December 22, 2021

**Re: US Eagle Credit Union- Menaul  
7201 Menaul Blvd. NE  
Request for Temporary Certificate of Occupancy  
Transportation Development Final Inspection  
Engineer's Stamp dated 1-18-21 (H19-D090)  
Certification dated 12-15-21**

Based upon the information provided in your submittal received 9-24-21, Transportation Development cannot approve the release of Temporary Certificate of Occupancy for the above referenced project.

TRAFFIC CIRCULATION LAYOUT
APPROVED
1/20/2021

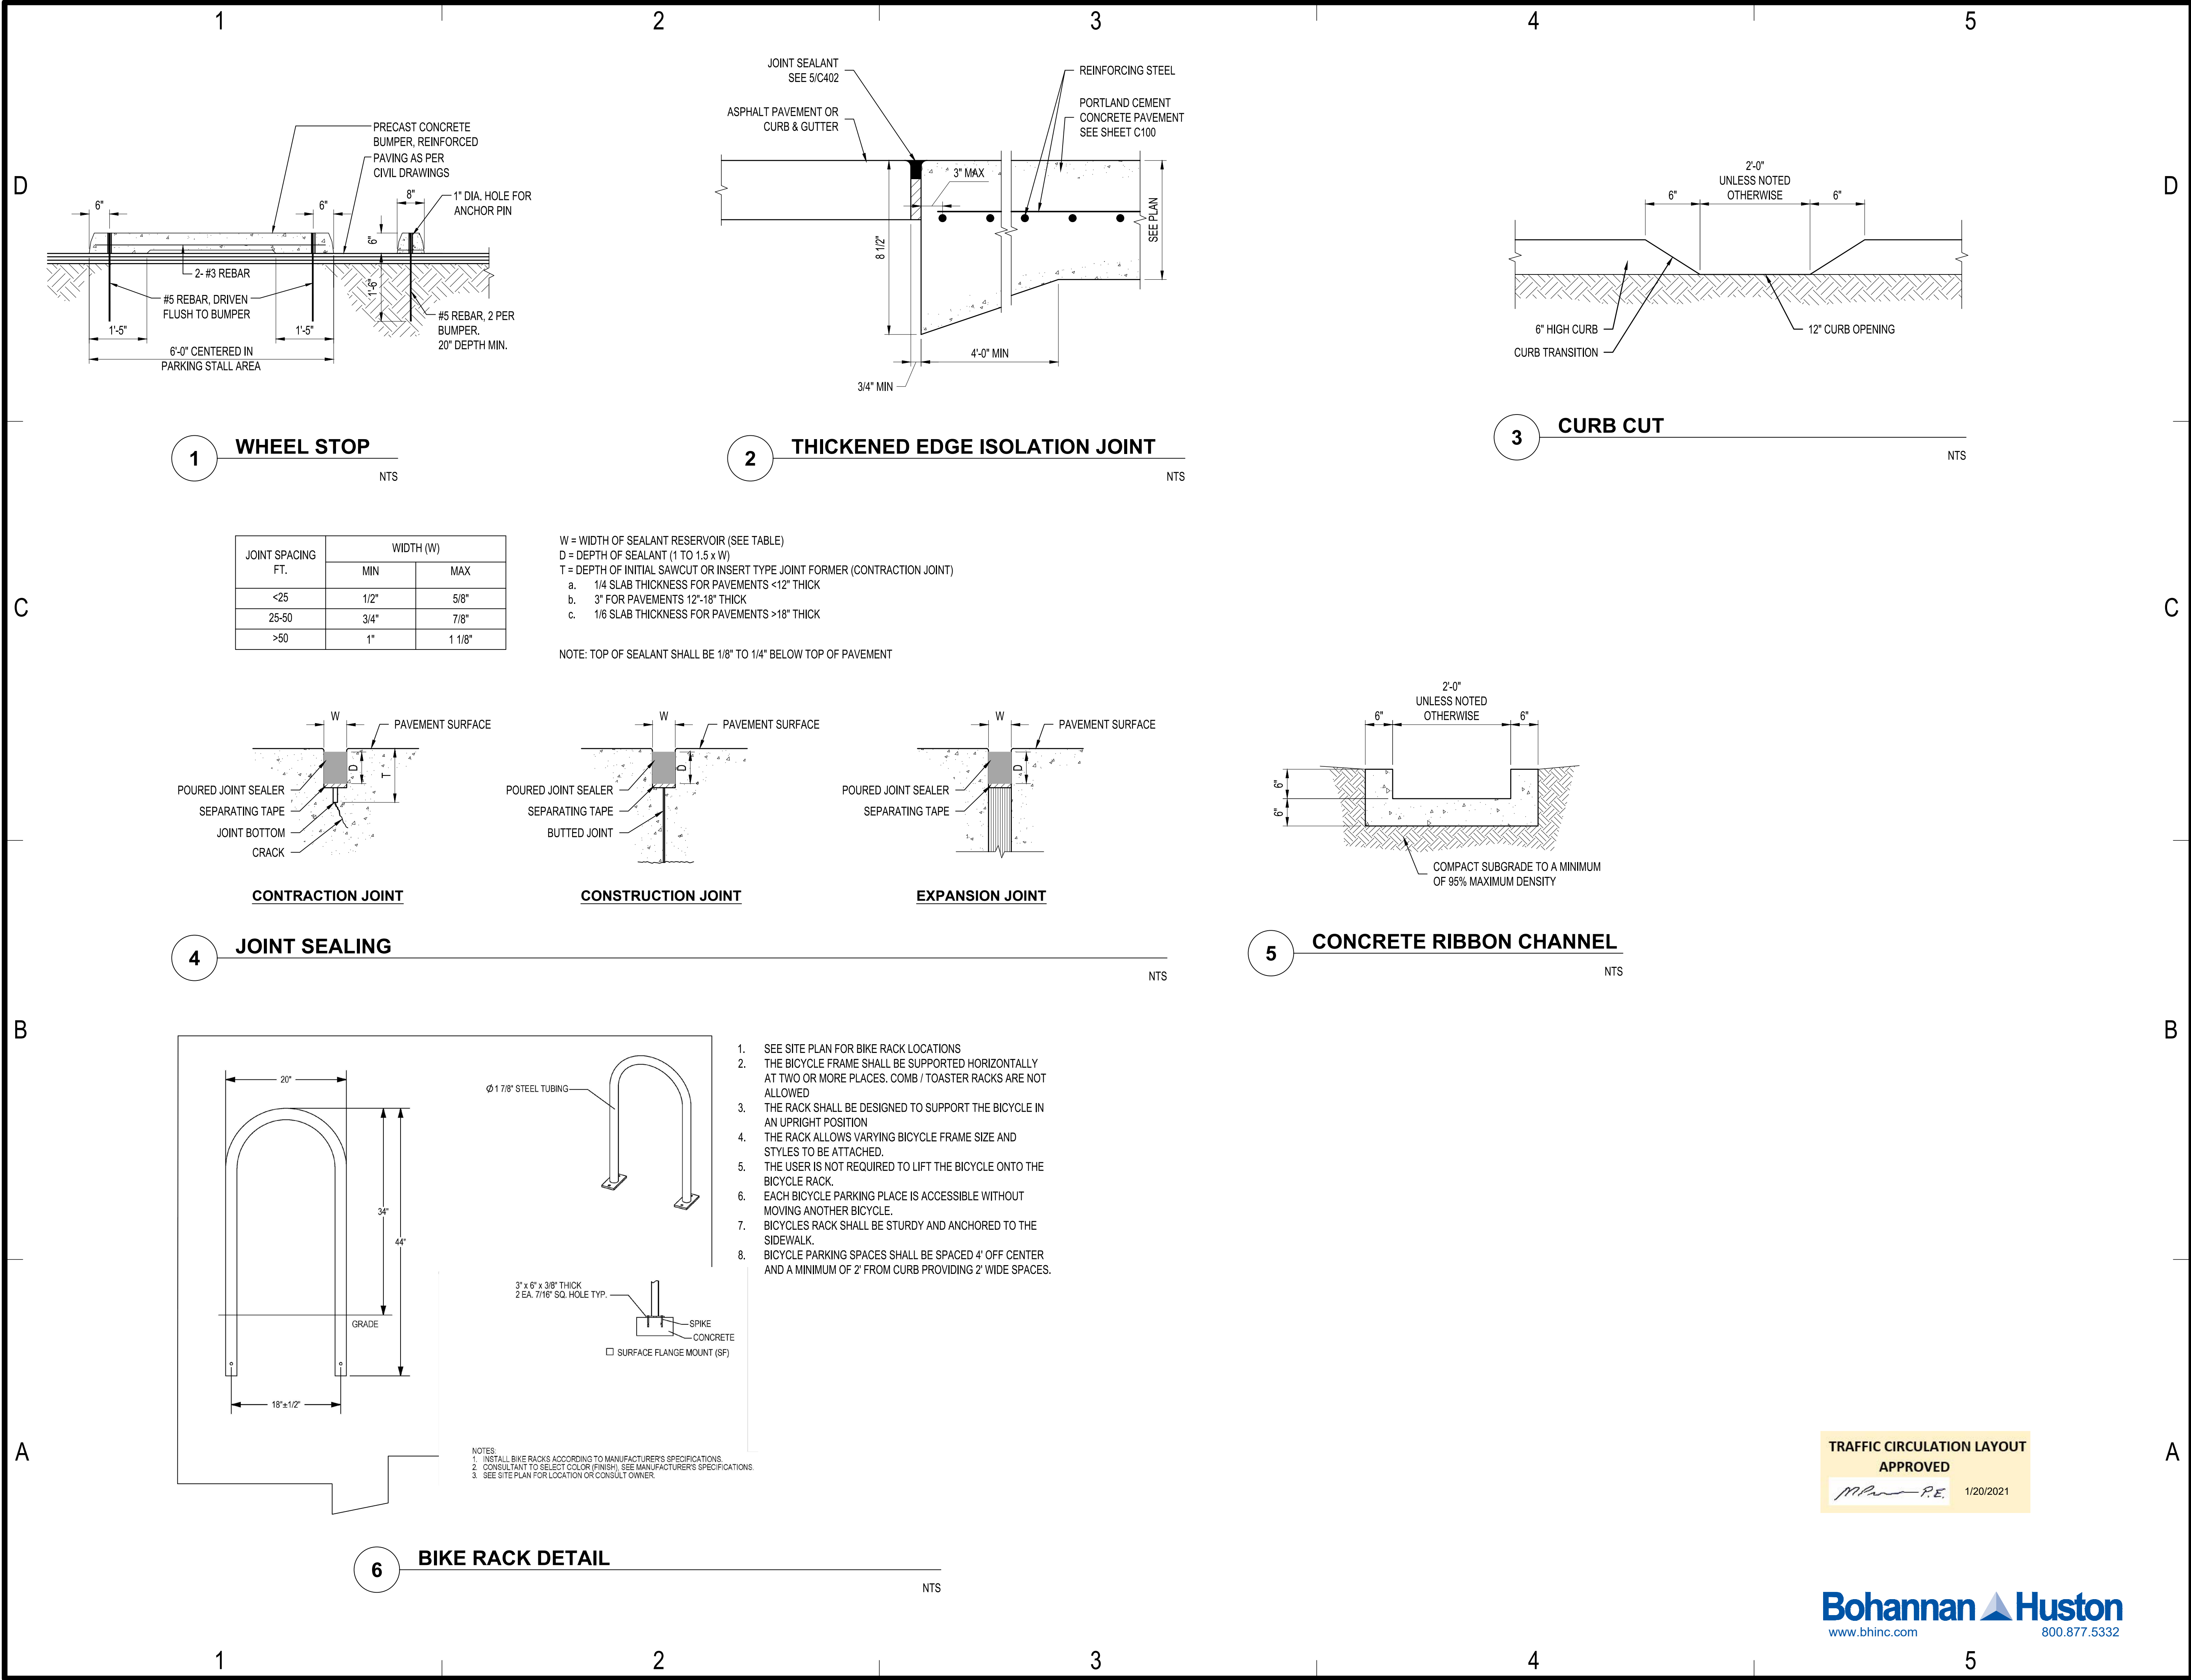
- **Safety Issue:** There is a **Hole** between parking spaces and the sidewalk off Menaul, and **Power lines** exposed. Please address this concern.
- Clear up the hole off Menaul, and cover the electric line.
- DO NOT ENTER signs and DO NOT ENTER pavement marking need to be placed inside private property.
- All one-way drives shall have "One Way" signage.
- Provide VAN ADA Parking space and VAN ADA accessible Aisle. Van accessible aisles should be 8ft wide.
- Explanation: why a Temp CO is requested?
- Remove construction equipment and debris from site.
